Please ask for: Ms Iqraa Malik
Email: iqraa.malik@terraquest.co.uk
Telephone: 0121 234 1390
Our Ref: R/168/24/PL
Your Ref:
Date: 12th November 2024

Application for Planning Permission

Development: Install patio doors to enclose the current open balcony area.
Location: Climping Court, Flat 12 Rackham Road Rustington BN16 2LQ

Drawing Existing Location & Site Plan

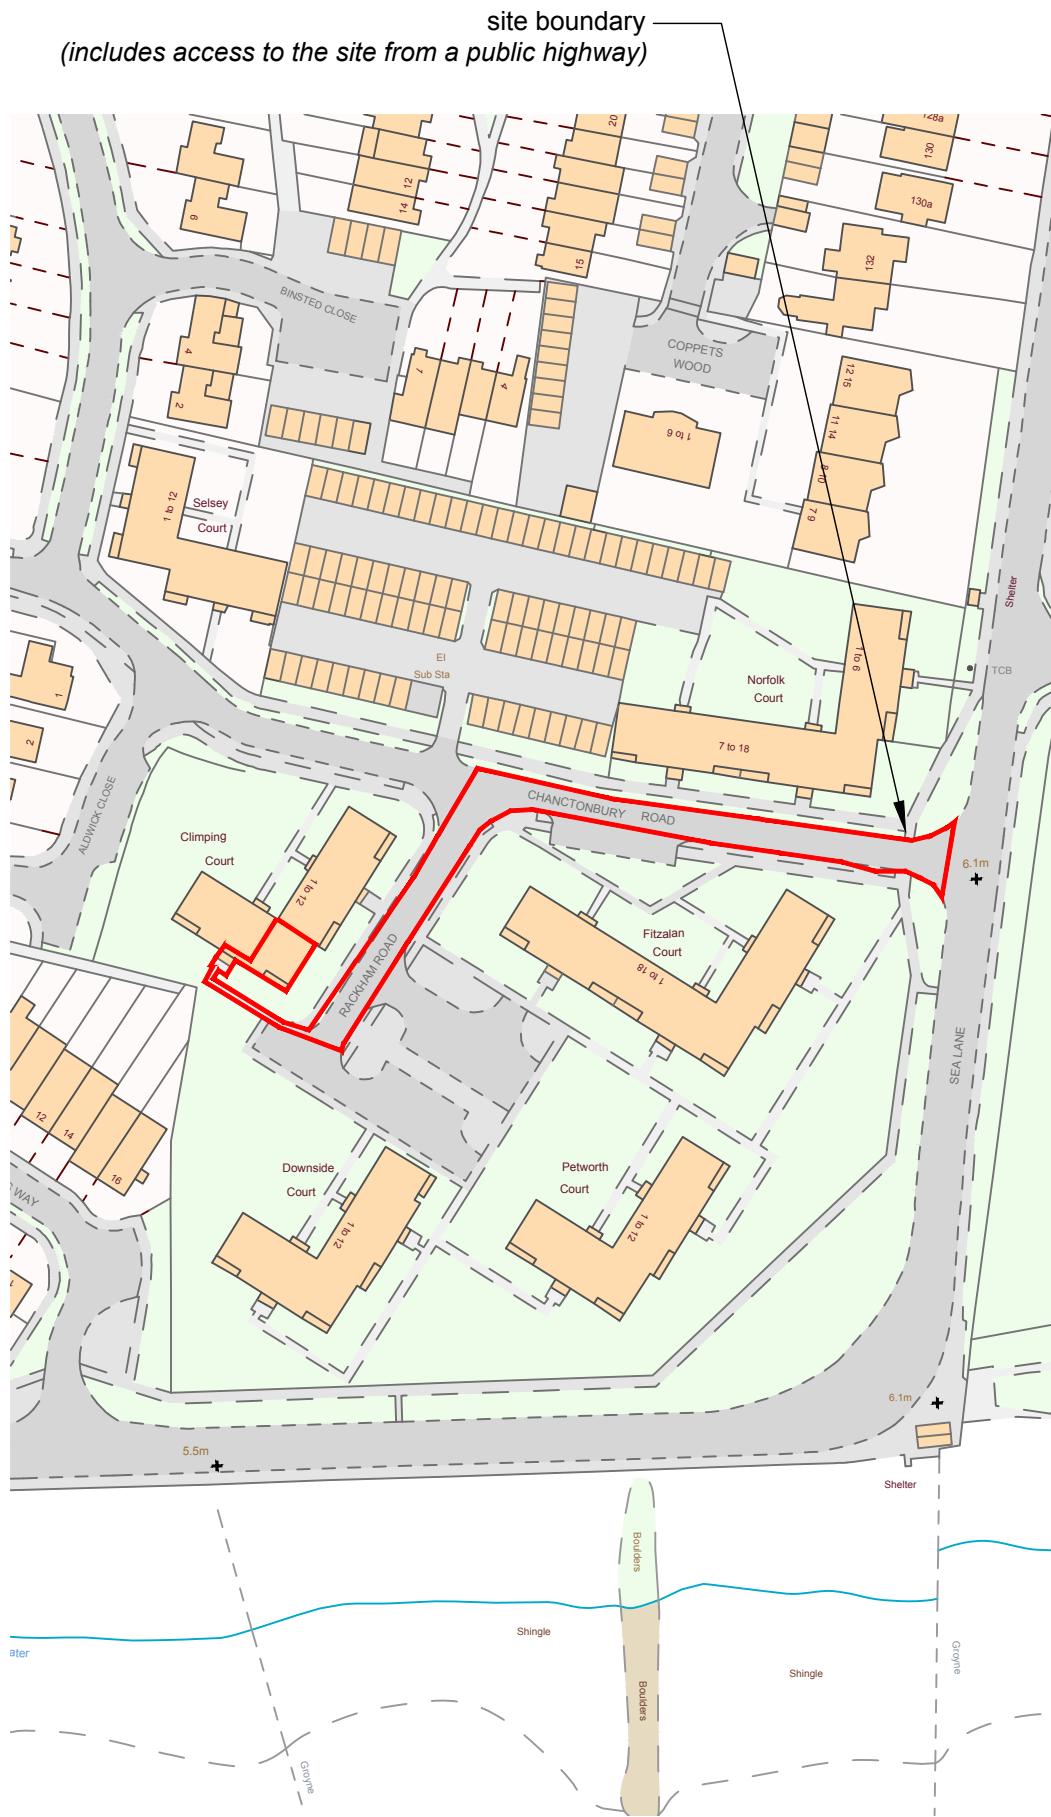
Location Plan Insufficient

The location plan requires a solid red outline around the site boundary, the outline must also include access to the site from a public highway, please review and amend. Further details of what must be included on the plan can be found in the Validation Requirements List.
